**Ref: Biopark, Broadwater Road, Welwyn Garden City, AL7 3AX**

Thank you for consulting me for the submitted Major Application comprising the demolition of existing buildings and construction of 289 residential units (Use Class C3) and community hub (Use Class E/F.2), with public realm and open space, landscaping, access, associated car and cycle parking, refuse and recycling storage and supporting infrastructure.

1 East Elevation
1 : 100

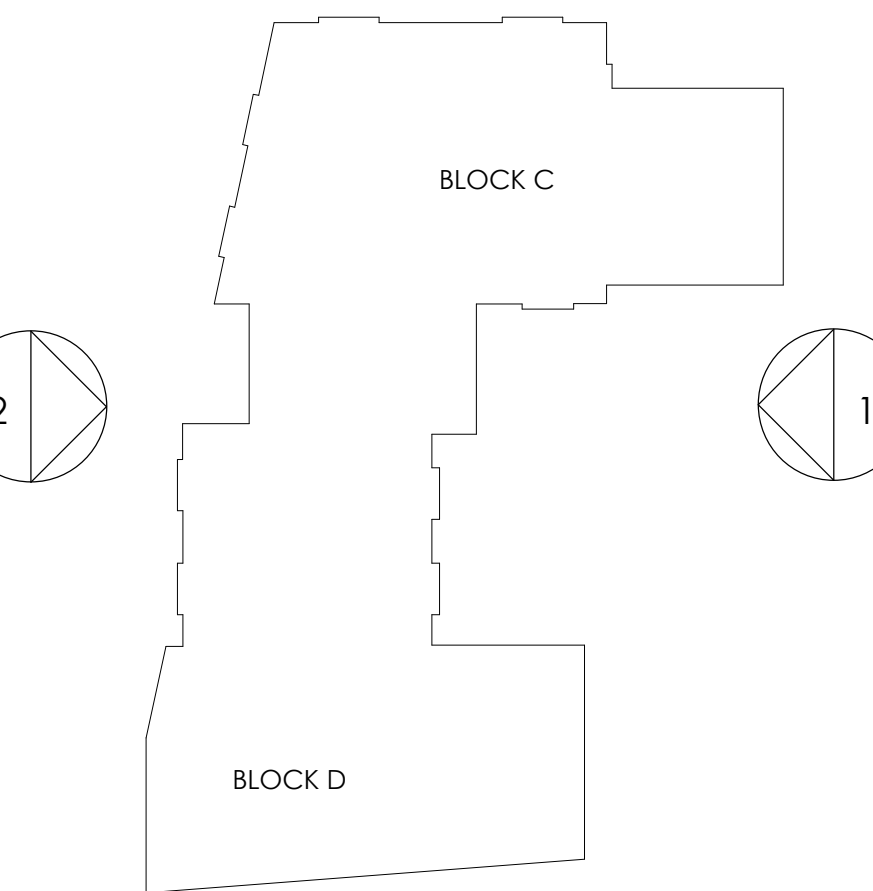
Building on my previous comments, I welcome the inclusion of an 'entrances study' within the DAS document which shows how the entrance to each block has been defined. I am still not convinced that the fairly simplistic approach to the entrances to Blocks A, B, C and D (Block E is considered appropriate given the art deco aesthetics of the block). Whilst this is not significant enough concern to warrant a recommendation of refusal on this point, I would like to see the applicant consider how the entrances could be more prominent – as I still have concern that they are not strongly evident enough in the overall building elevations.

1 North Elevation
1 : 100

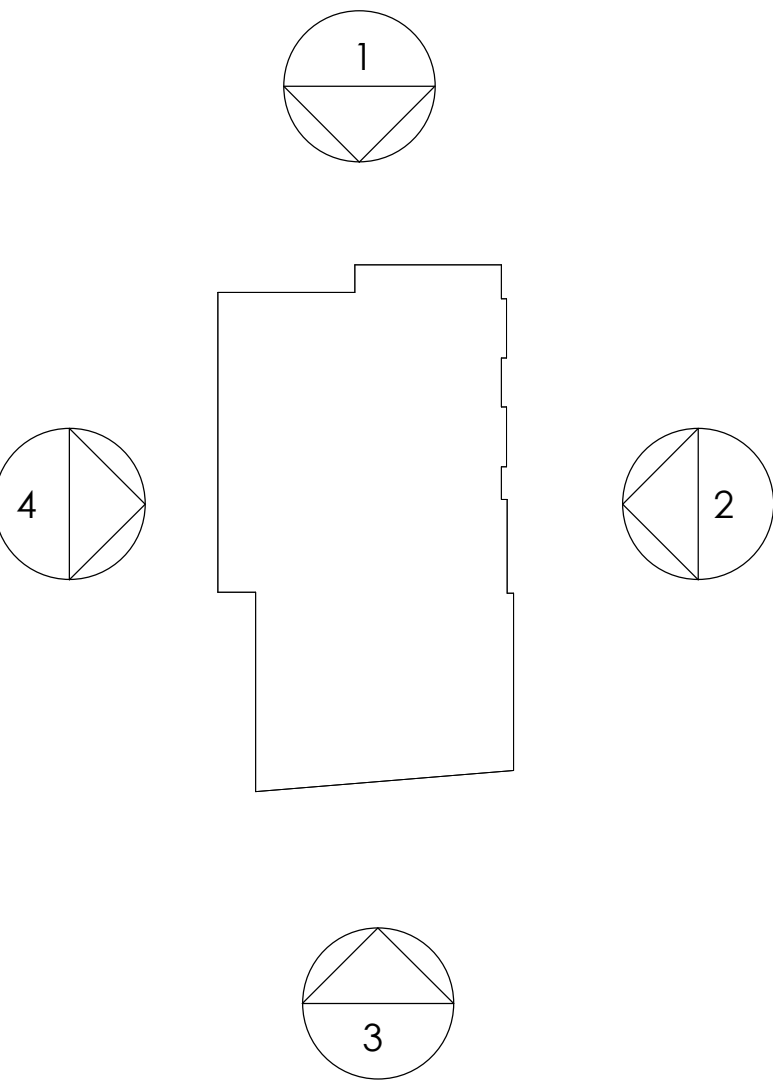
Whilst I welcome the mansard approach to all buildings, I would like to see a variation of Block E, potentially showing how a brick frame could be created by extending the brickwork up to approximately half the height of the mansard roof, with the roof itself sitting behind the frame. It is possible that due to its lower height, that the full height mansard on Block E may appear slightly contrived, and I therefore consider that potentially increasing the brick detail slightly higher through a box frame might help alleviate this.
